Lawful Development Certificate Proposed application					
Application ref	23/01583/LDCPR	Officer	Christopher Park	Date	11/08/2023
Address	24 North Street, Cowden, Edenbridge, Kent, TN8 7JA				
Description of proposal					
Installation of a solar photovoltaic panel system on the roof.					
Relevant planning history					
None					
Have permitted development rights been removed? Y/N				N	
Further comment:					
No original permission for the property could be found, thus the presumption is that permitted development rights have not been removed.					
Article 2(3) land:					
Area of Outstanding Natural Beauty (AONB)	X	Conservation Area (CA)		X	N/A

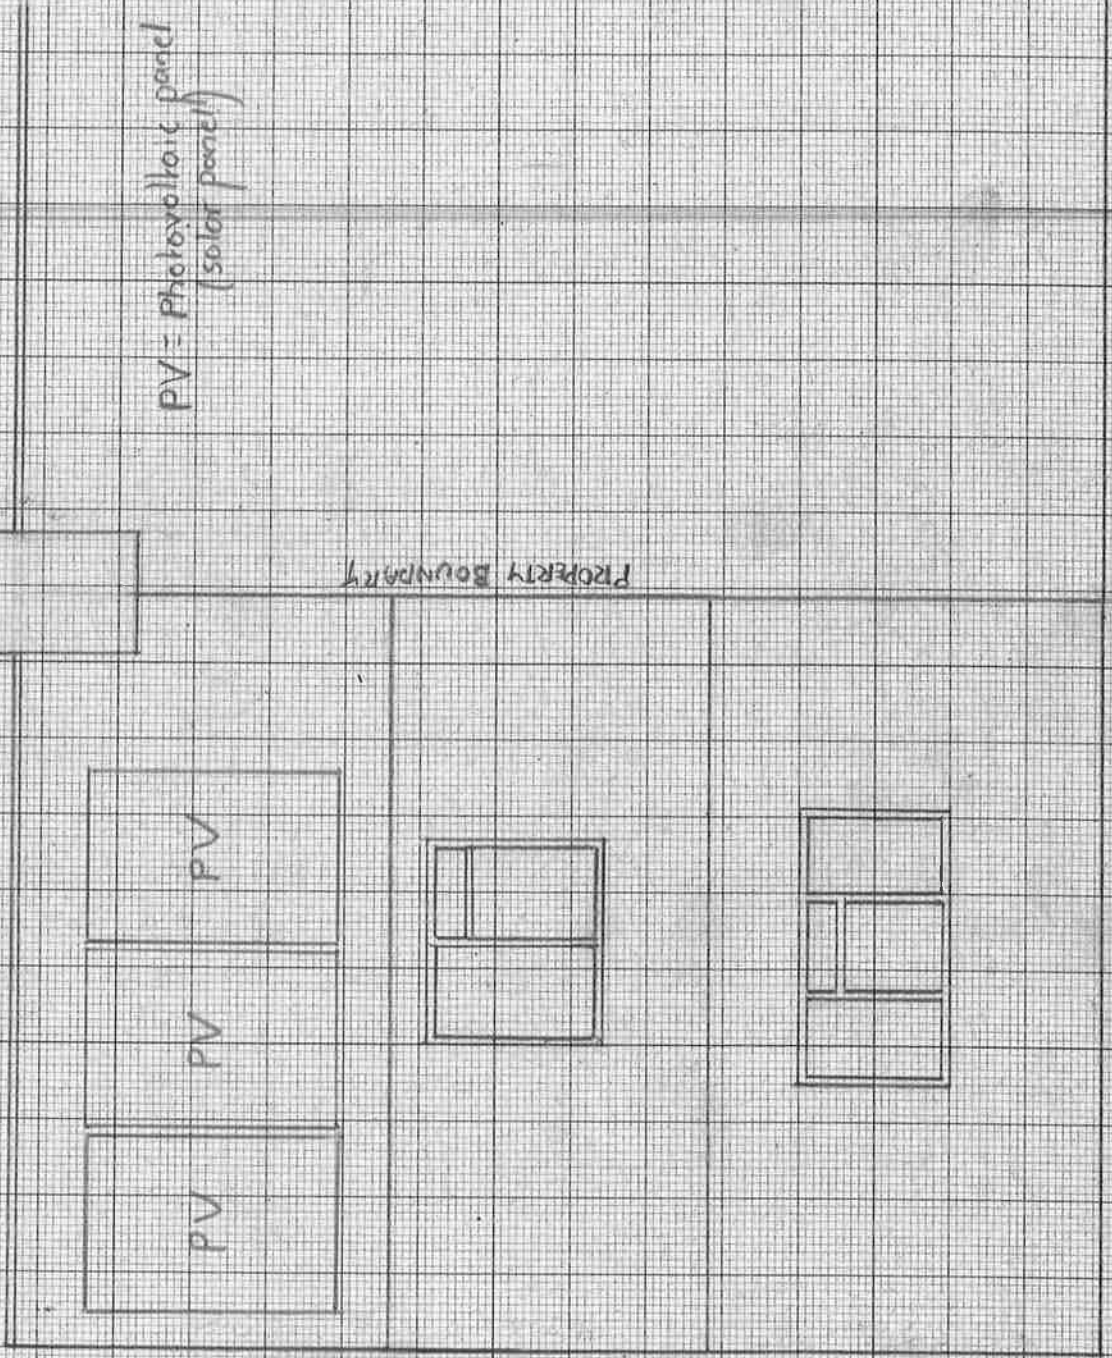
(a)	the solar PV or solar thermal equipment would protrude more than 0.2 metres beyond the plane of the wall or the roof slope when measured from the perpendicular with the external surface of the wall or roof slope	N	Whilst the solar panels within the roof slopes of the main dwellinghouse would protrude less than 20cm, the solar panels on the flat roof addition to the rear would protrude more than 20cm at their highest point.

(a)	solar PV or solar thermal equipment is, so far as practicable, sited so as to minimise its effect on the external appearance of the building;	Y	The proposed panels are to be situated comfortable within the silhouette of the front and rear roof slopes. Therefore, the proposed panels would have a minimal effect on the external appearance of the building.

As a result of the panels projecting more than 0.2m beyond the plane of the flat roof addition to the rear, the proposal does not comply with Schedule 2, Part 14, Class A of the Town and Country Planning (General Permitted Development) (England) Order 2015 (as amended) and therefore, planning permission is required.
